Consultation Response from KC, Lead Local Flood Authority		
2020/92350 Land south of, Heybeck Lane, Chidswell, Shaw Cross, Dewsbury		
Outline application for residential development (Use Class C3) of up to 181 dwellings, engineering and site works, demolition of existing property, landscaping, drainage and other associated infrastructure		
Date Responded: 21st September 2020	Responding Officer: Paul Farndale	Responding Ref:

Summary for Planning Officer

### **Drainage Strategy**

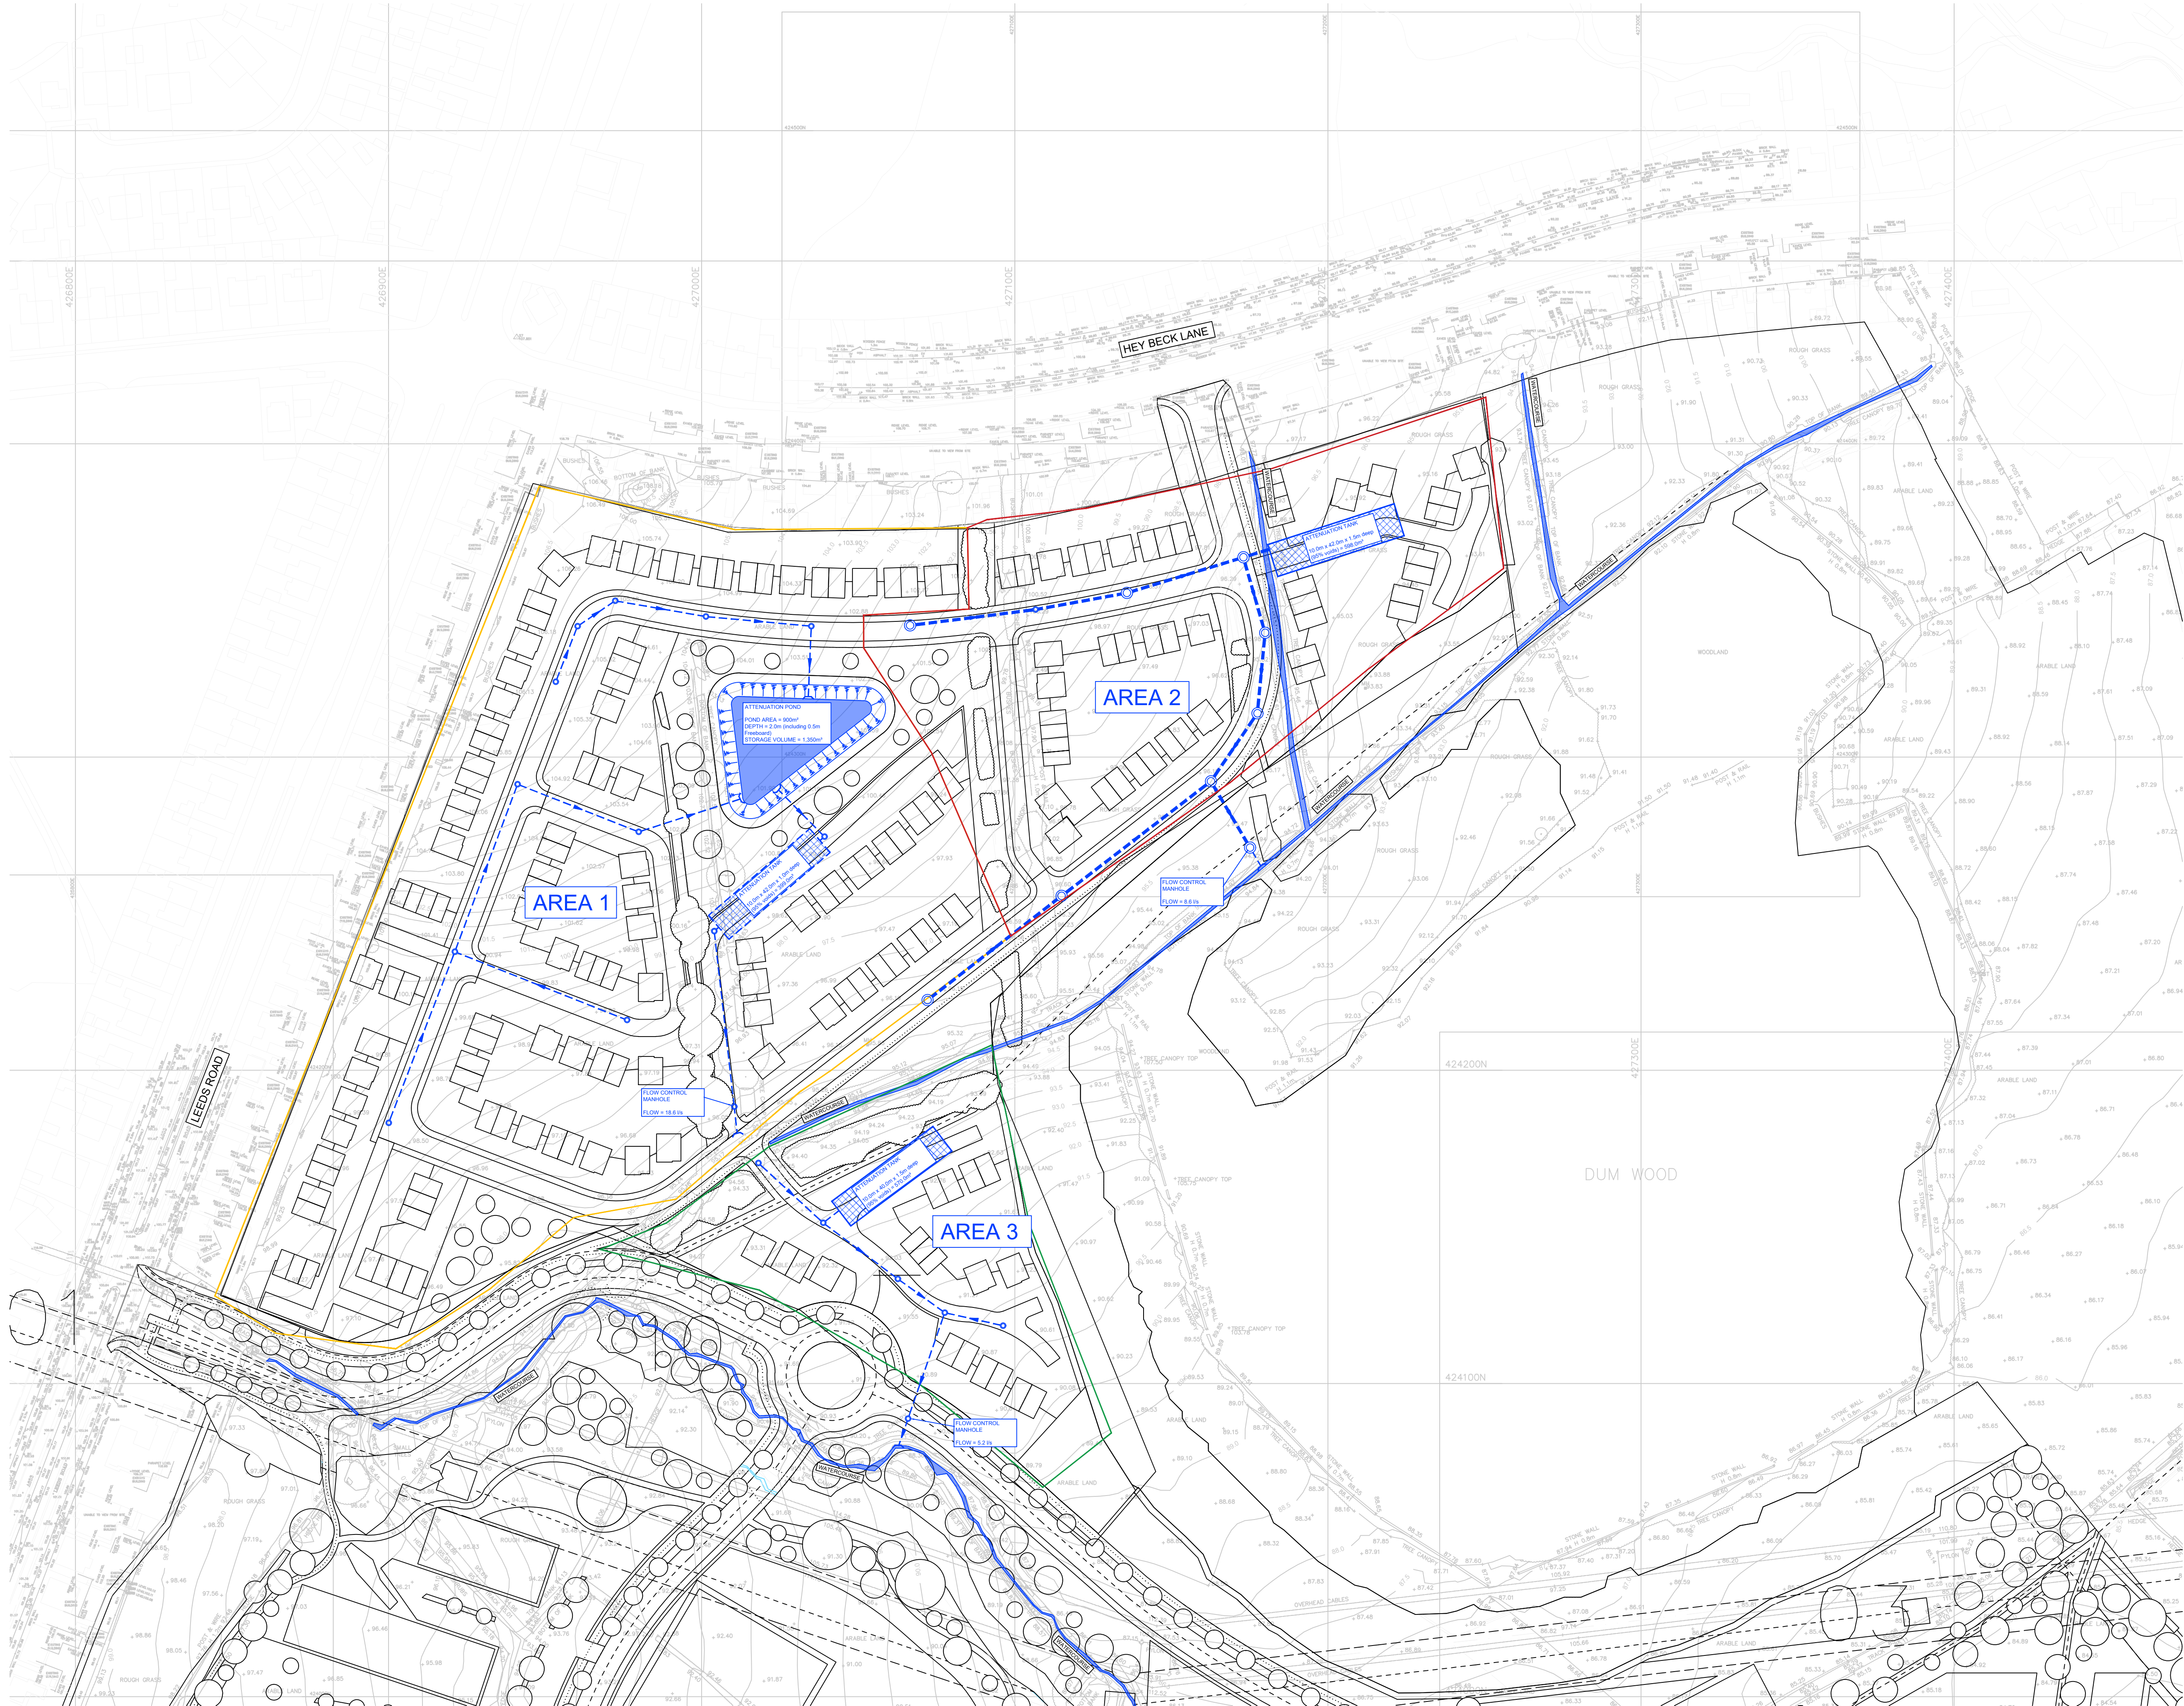
- Kirklees Local Plan flood risk documents for the site produced by RES should form part of a detailed assessment and be expanded upon.
- A discharge rate of 32.4l/s as stated in the submitted FRA is not accepted by Kirklees LLFA. A clear demonstration of the area to be developed with current contours should be evidenced. The site will be allowed a discharge rate of 5l/s/ha for areas that naturally drain to the discharge location. Landscaped areas that continue to drain as 'greenfield' should be excluded in this analysis so as not to 'double count' any areas.

- Kirklees Council Policy allows for a 30% increase in rainfall to reflect potential climate change.
- Whilst layout is a reserved matter, Kirklees LLFA has concern that any drainage strategy forms part of a connected masterplan where reasonably practicable. Space must be made for attenuation toward to lower parts of the site. The indicative plan therefore gives cause for concern that this may have been omitted to date. Exceedance routes must avoid property and curtilage. It is therefore vital that existing topography demonstrates current overland routes and any design seeks to keep these routes without putting houses in harms way. The road network and open spaces are encouraged to be used for flood routing.

- As of April 1st, 2020, a change in the legal definition of public sewer allows sever green SUDS techniques to be used on site AND adopted by Yorkshire Water. Even if infiltration proves difficult is expected that the developer examines the potential of SUDS both for amenity value and as an opportunity to improve the quality of the discharge by provide a 'treatment train' in the drainage design.
